**Consultation Response from KC Lead Local Flood Authority**
**2019/92587 Wheelwright Centre, Birkdale Road, Dewsbury, WF13 4HG**
**Alterations and partial demolition to convert existing building to form 65 residential units, installation of mezzanine floors, associated landscaping works (soft & hard landscaping) and car parking layout (within a Conservation Area)**
**Date Responded:**  
 01/11/2019

**Summary**

Kirklees Flood Management and Drainage as the Lead Local Flood Authority **OBJECT** to this planning application on the following grounds;

- **Drainage Strategy, submitted by Jameson Consulting, Dated 16<sup>th</sup> September 2019 (uploaded 25/09/19).**

PROPOSED DRAINAGE PLAN
Scale 1:250

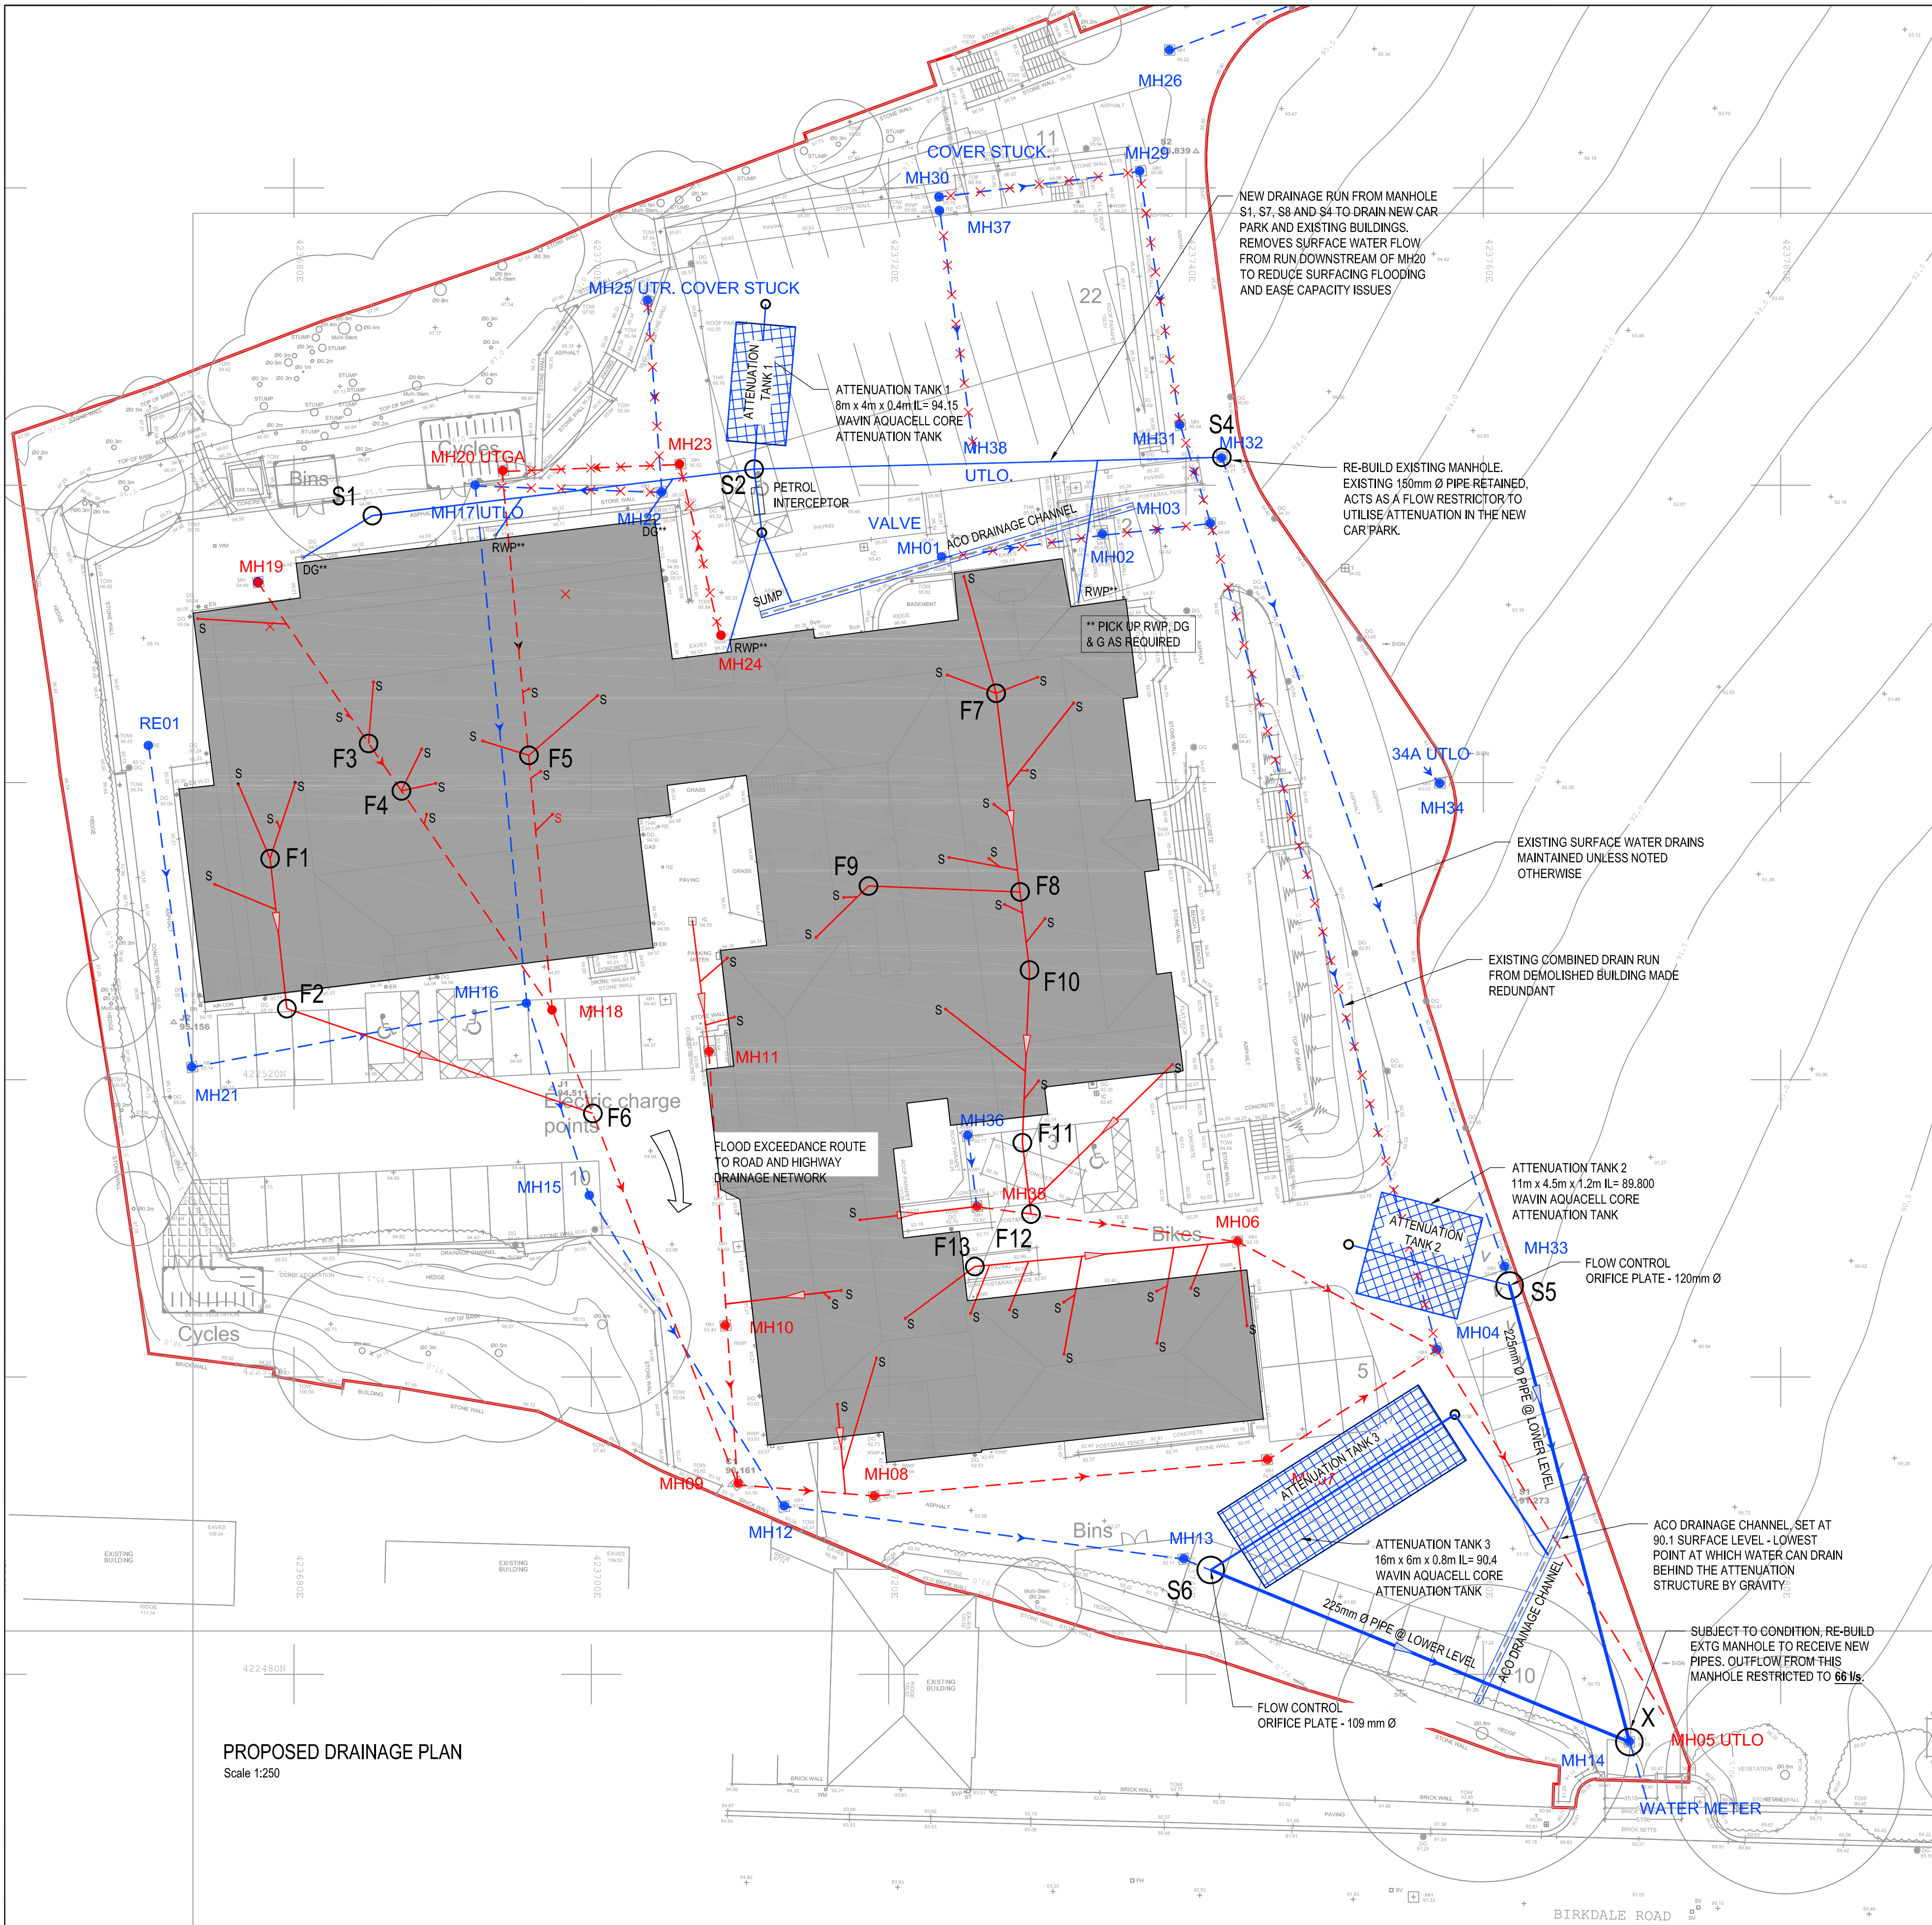
Flow routing from the development captures only areas to the side and south of the site, the primary area of concern is to the North of the site where the building construction could impound overland or exceedance flow. **The applicant is required to investigate this and identify whether landscaping or similar is required.**

Kirklees LLFA acknowledge that the most suitable point of connection for the site is to the Yorkshire Water surface water sewer. The applicant's drainage consultant proposes a restricted discharge rate of 68.5 l/s (section 3.5). **Kirklees LLFA require the full calculations and input data used to justify this rate including an impermeable contributing area plan.** Without this evidence Kirklees LLFA cannot

It is note in section 3.14 that it is proposed for the existing access road serving the development to discharge unrestricted to the surface water network by running onto the carriageway. **Kirklees LLFA object to this proposal; the applicant should capture all surface water originating onsite and manage it's discharge safely into the surface water network. The applicant is required to provide a 30% reduction on all site contributions.**
